May 22, 2020

RE: Peaks Center Addition No. 1 Annexation – Initial Review Comments
File(s): CPC A 19-00134, CPC ZC 20-00032, CPC CP 20-00033

This letter is in response to the 1st Review Letters dated March 2, 2020. Our responses are below in red.

PEAK CENTER ADDITION No. 1 ANNEXATION

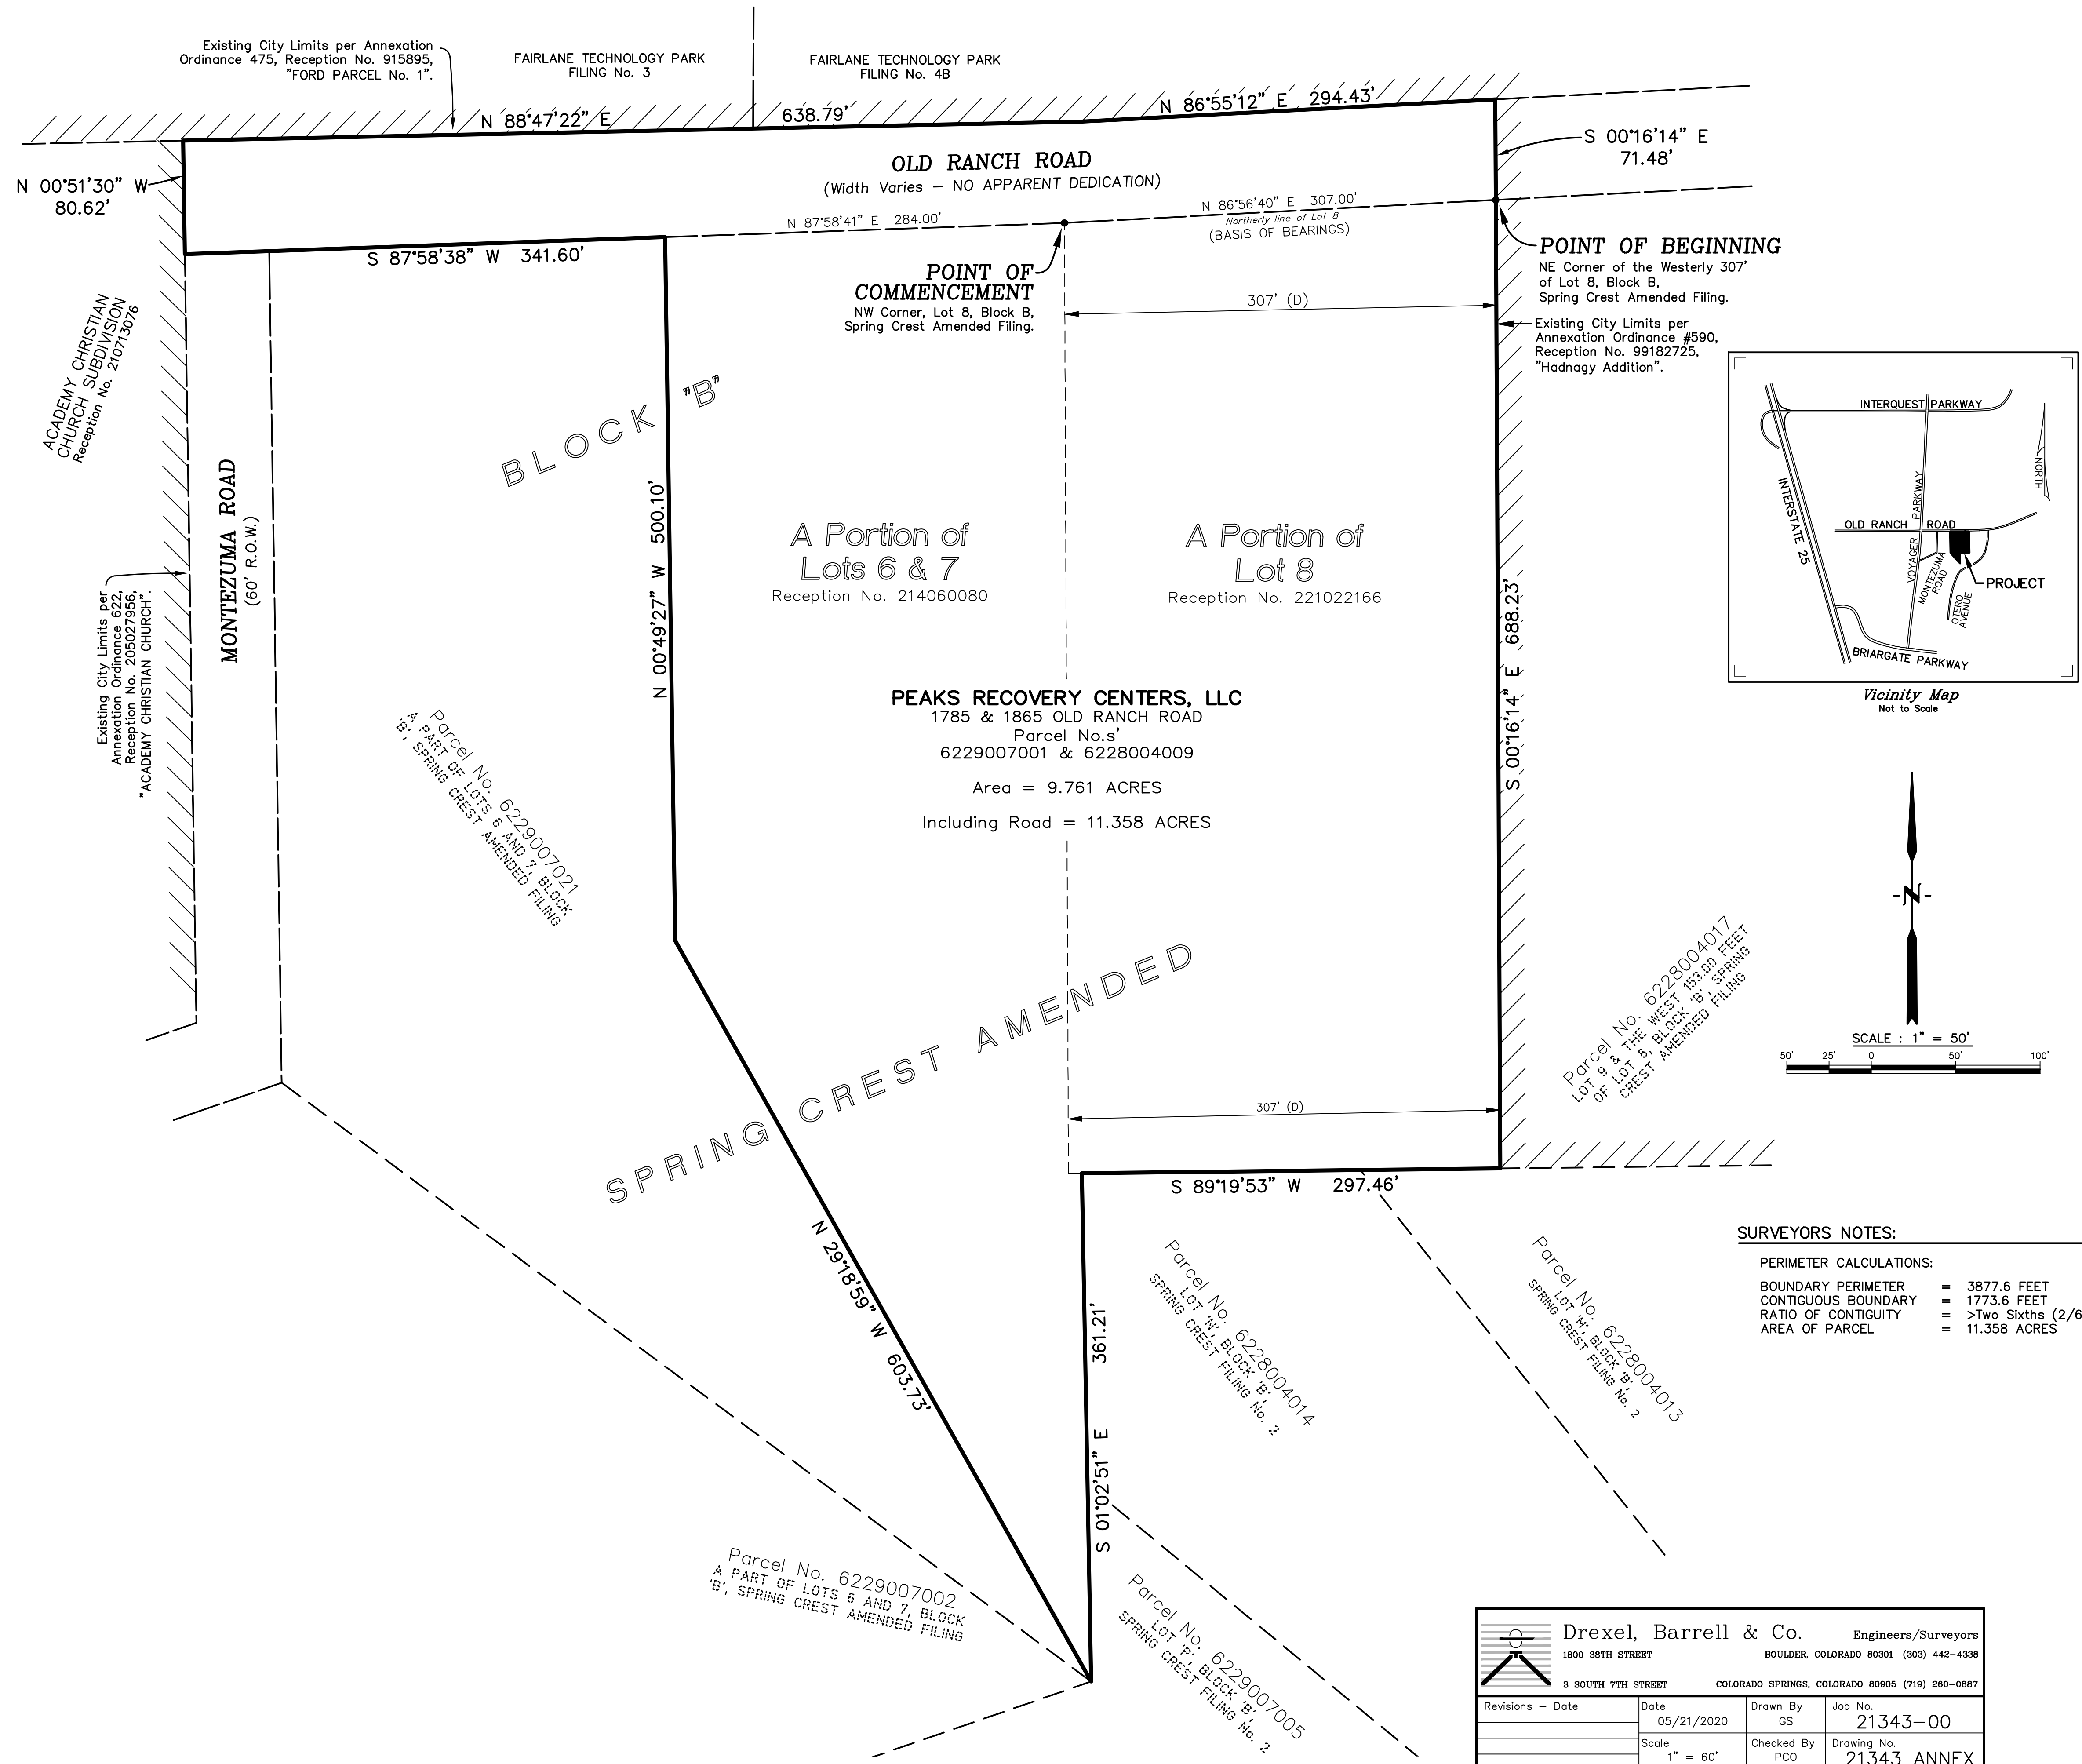
1. Please check the name in the title and City approval as they differ. – **Reconciled.**
2. Is Peaks Recovery Centers LLC a Colorado Limited Liability Company? If so please add "a Colorado Limited Liability Company" to each of the locations that they name appears. – **Added.**
3. Please revise all the year dates to "2020". – **Revised.**
4. Please revise the last part of the City Approval as follows:
The annexation of the real property shown on this plat is approved pursuant to an ordinance made and adopted by The City of Colorado Springs, El Paso County, Colorado, by actions of The City Council of The City of Colorado Springs at its meeting on _____ day of _____, 20__ A.D.

5. Please add the City File No. CPC A 19-00134 in the lower right hand corner of the sheet. – **Added.**
6. Please fill in the blank reception number for "ordinance 475" as shown near the northwesterly corner of the drawing. – **Added.**

City Clerk Date – **Revised.**

CONCEPT PLAN

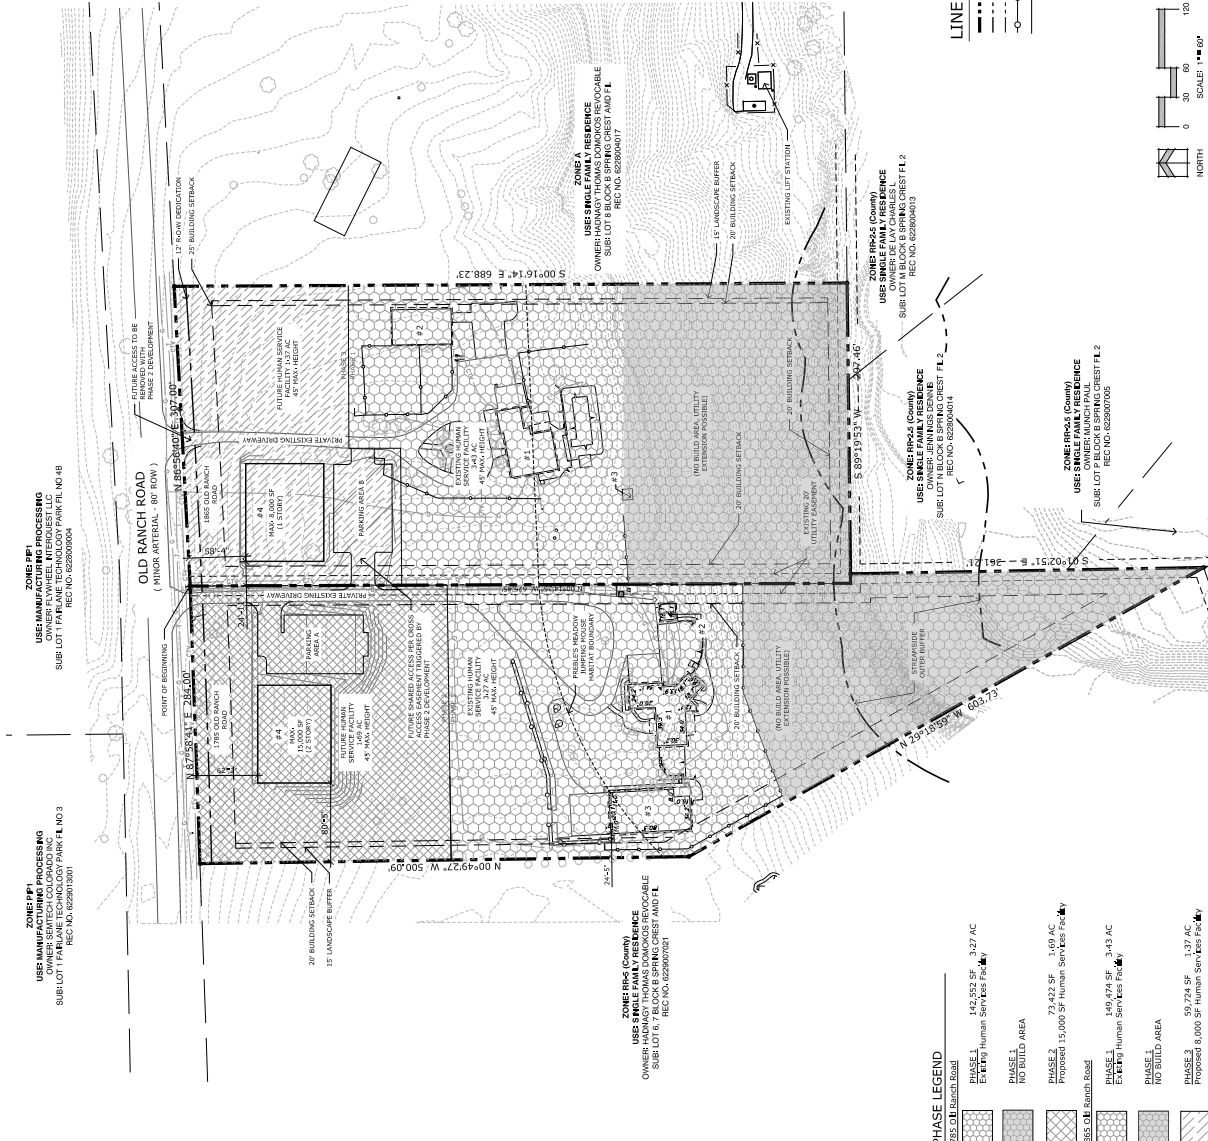
1. Add the concept file number to the bottom right corner of each sheet -- **Added.**
2. Site Data: please update or change as appropriate within notes or depiction

- a. Front setback for OC is 25-feet, please update setbacks per OC zoning district -- **Setbacks have been updated per OC zoning district.**
 - b. Please show the side setback along the eastern side of the property -- **Shown.**

- c. Would there be a way to merge the parking data with the building table created? Staff thinks this will more clearly represent the required parking per buildings and use type. -- **Combined.**

5. Depict on the plan the line for the Preble's Meadow Jumping Mouse – **Depicted.**
6. Update the phase lines to better depict the different phases – **Updated.**
 - a. Phase lines for phase 1 should encompass both lots although separate. No need to show two phase 1 areas for clarity.
7. Phase 3 shows a proposed new building but does not give allocation for parking with this building, please update – **Updated.**
 - a. Per Traffic Engineering's comment below staff would ask that future phases of development establish a single point of access that would then serve the new buildings and parking areas as well as access to the existing buildings.

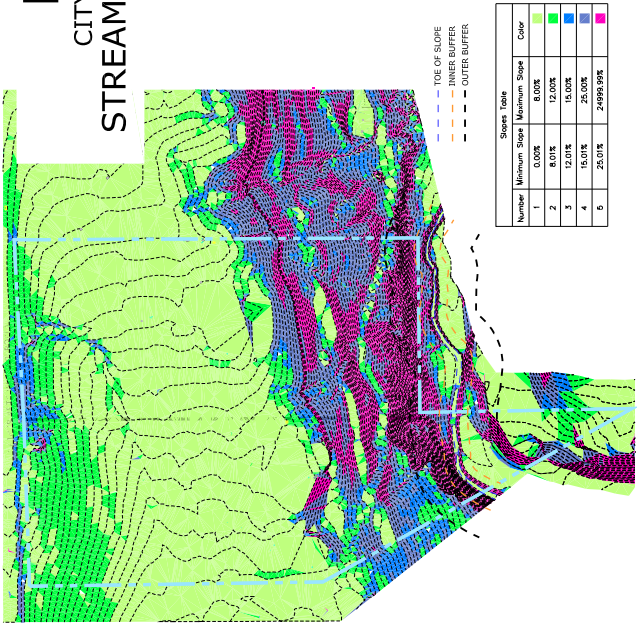
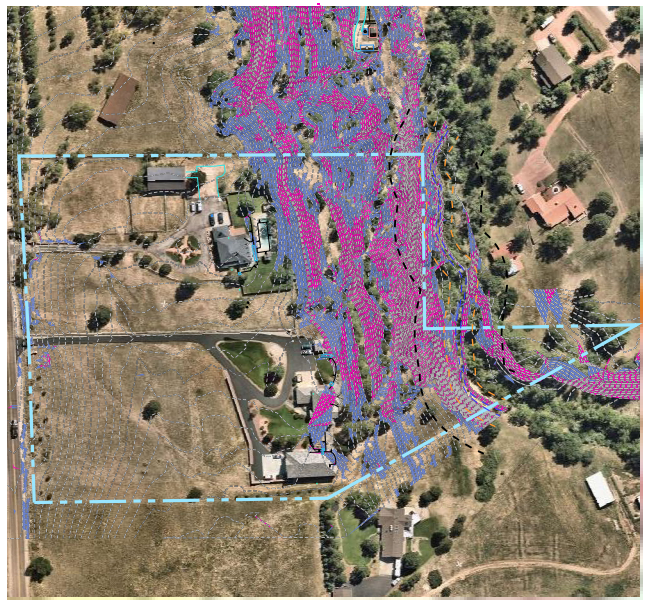
2. Please add the term "Streamside" in front of the title of "Land Suitability Analysis" within the title block of the LSA sheet, and add the following items to the LSA sheet: – **Updated.**

- Show the streamside overlay buffers as well as the toe of the channel bank from which the buffers would be measured (consult the streamside overlay guideline document at the link below for instructions). For the purposes of this review, please assume a Type 1 Stream: 20' inner buffer/50' outer buffer. - – **Provided.**

- Label soil types on the soil analysis image within the LSA sheet. - – **Labeled.**
 - Provide a table showing the extent of any impervious surface existing or proposed within the overlay buffers. - – **Provided.**
